Rezoning Transportation Analysis

Petition Number: 2022-200

Revision Log:	Date	Description
	4-27-23	First Review (TM)

SCHEMATIC SITE PLAN

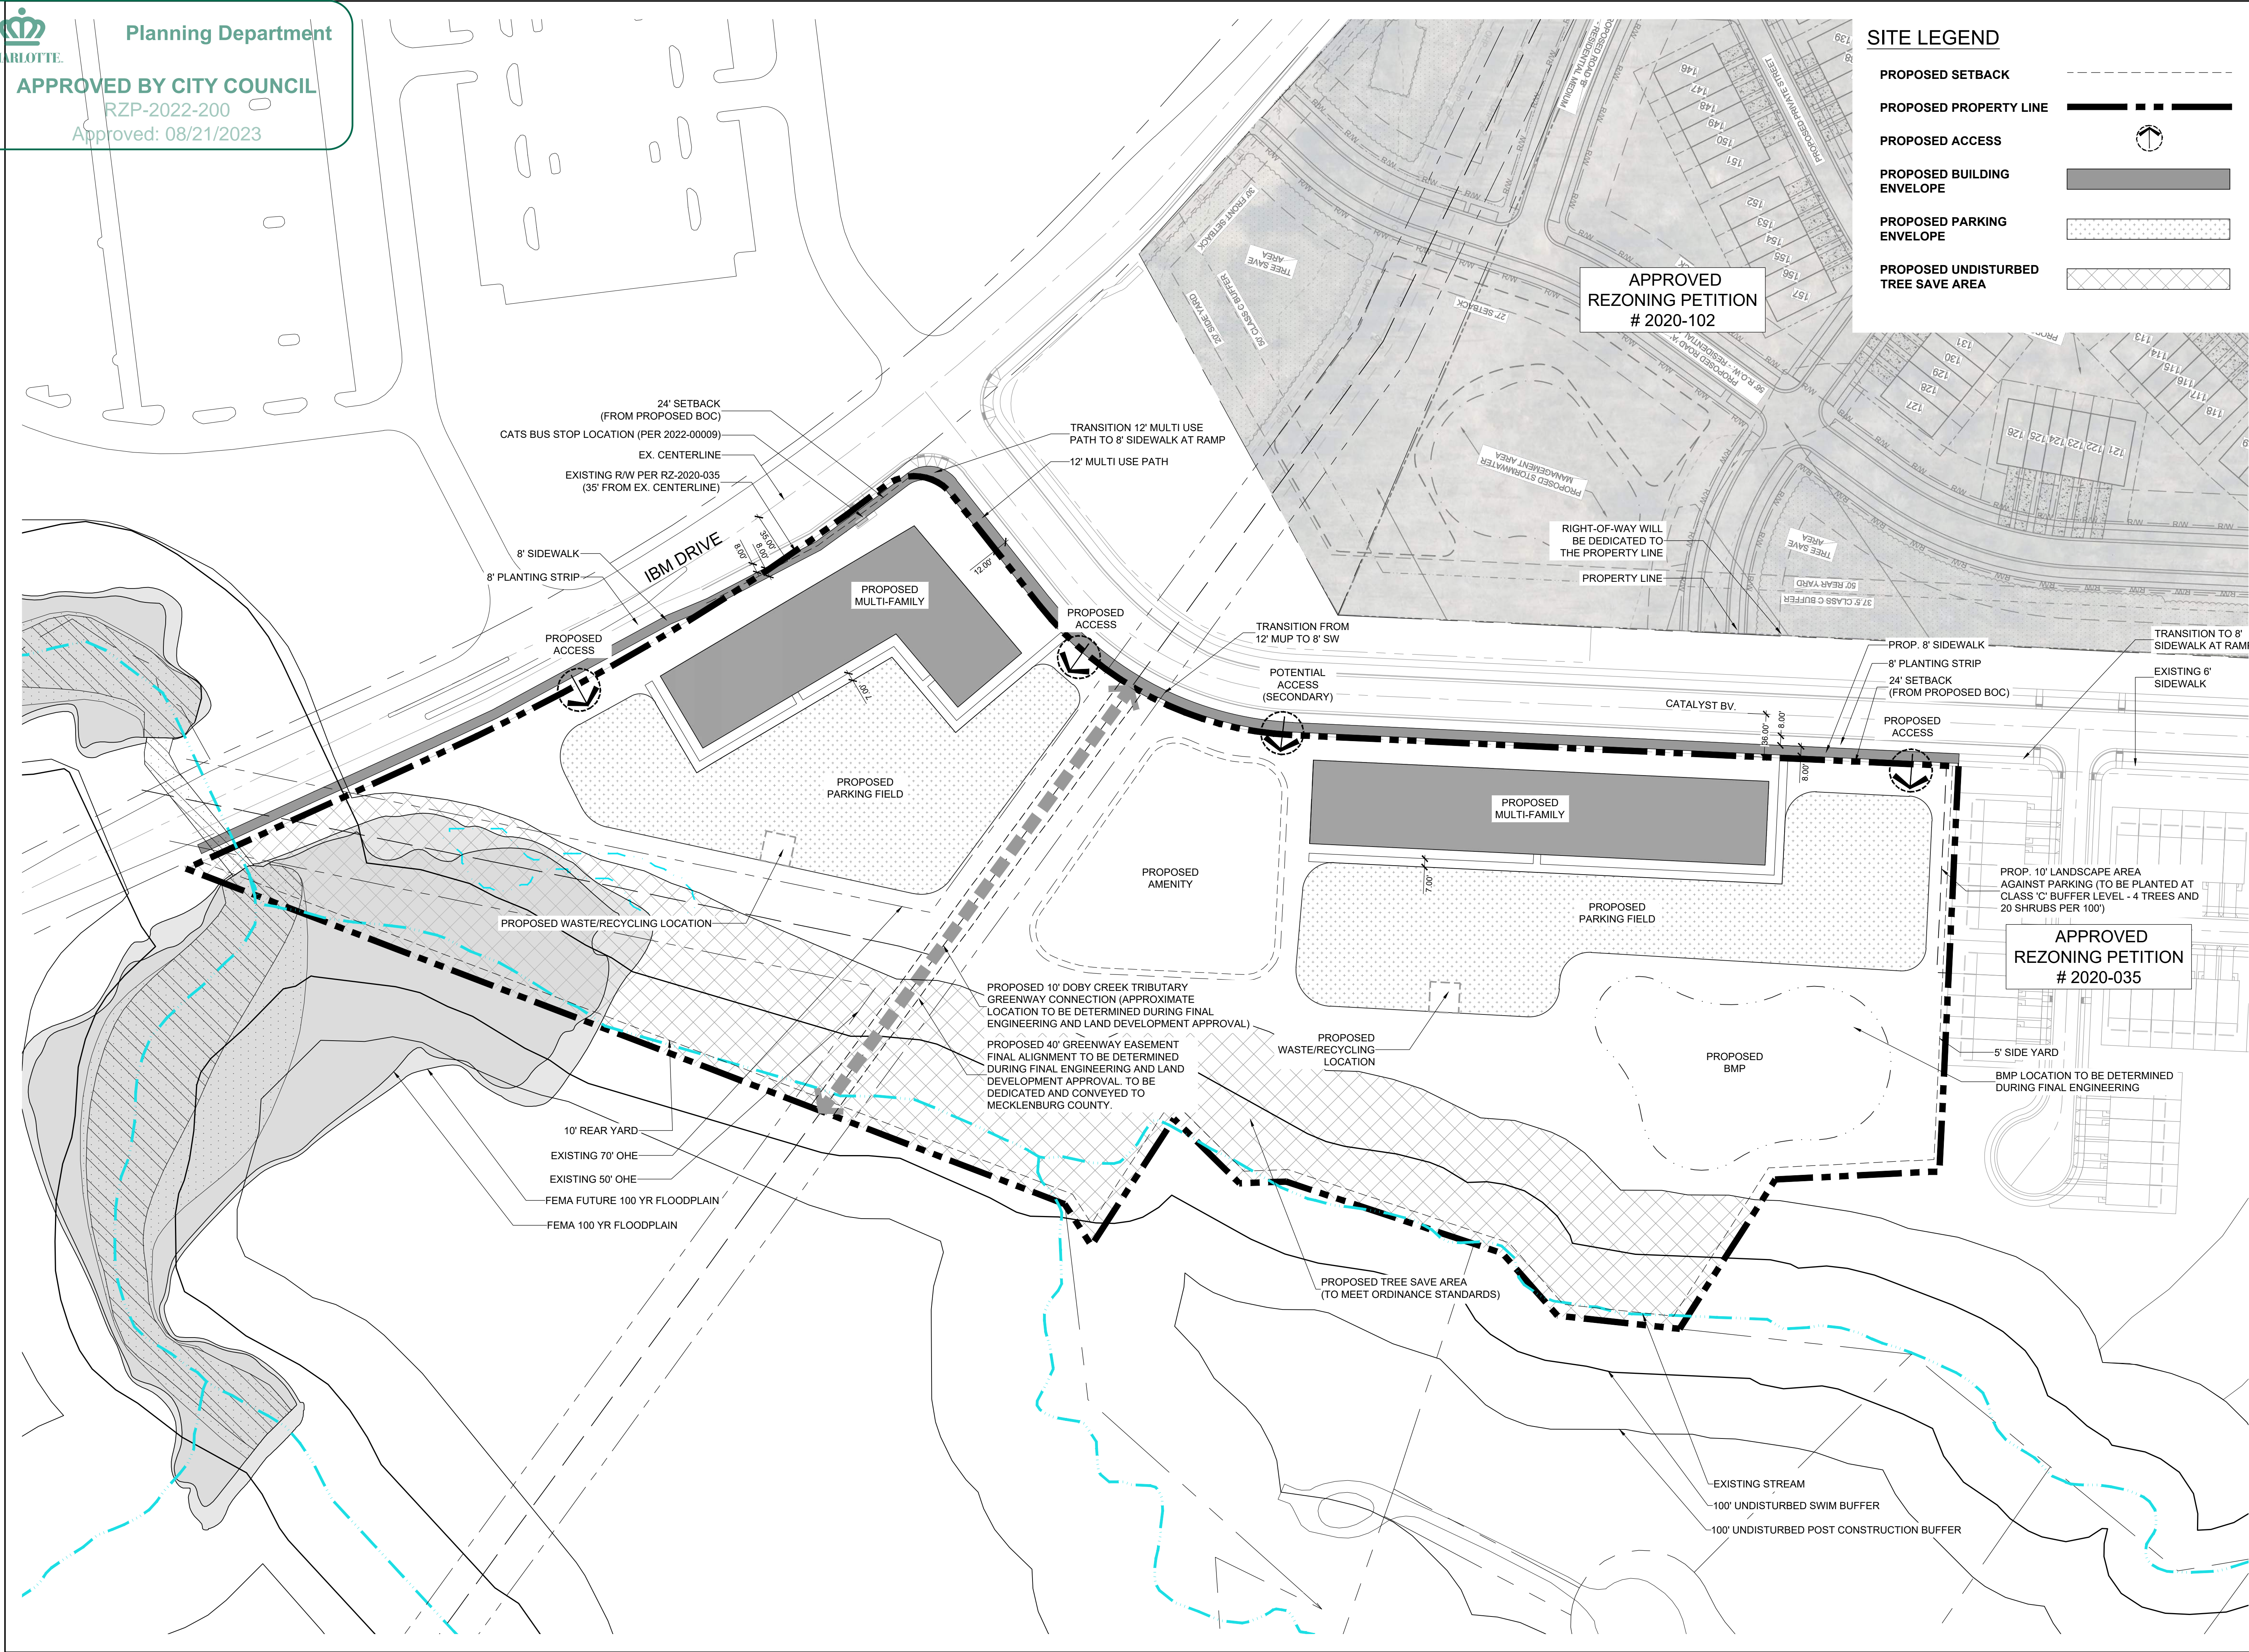
- a. **IBM Drive:** Location of curb and gutter to be moved to 19 feet from roadway centerline to accommodate the Charlotte Streets Map with a roadway typical section of 2+ Avenue with a Shared Use Path.
- b. **Catalyst Boulevard:** The future location of the curb and gutter is being constructed in accordance with detail U-07, Local Collector typical section from the Charlotte Land Development Standards Manual.

Label and dimension the curb and gutter from the centerline for each road on the site plan.

3. Revise site plan and conditional note(s) to commit to dedicate 35-feet of right-of-way from the road centerline of IBM Drive. The site plan shall label and dimension the right-of-way from the road centerline.
4. The proposed dwelling units exceeds 12 per acre. Per Chapter 20 Subdivision ordinance, revise site plan and conditional note(s) to commit to construct an 8-foot planting strip, and 8-foot sidewalk along Catalyst Boulevard. The wider sidewalk also meets the Charlotte WALKS Policy.

5. Revise site plan and conditional note(s) to commit to construct bicycle facilities by installing a 12-foot multi-use path to meet the Council-adopted Charlotte BIKES Policy on IBM Drive. Multi-use paths maintained by the City shall meet ADA/PROWAG requirements.
6. Revise site plan and conditional note(s) to commit to coordinating with CDOT on street and pedestrian lighting during permitting.

7. Revise site plan and conditional note(s) to commit to installing a 2 (inbound and outbound) CATS bus stops on IBM drive.
8. Revise site plan and conditional note(s) to commit to revising southern access location to align with the adjacent development access shown from rezoning 2020-102.
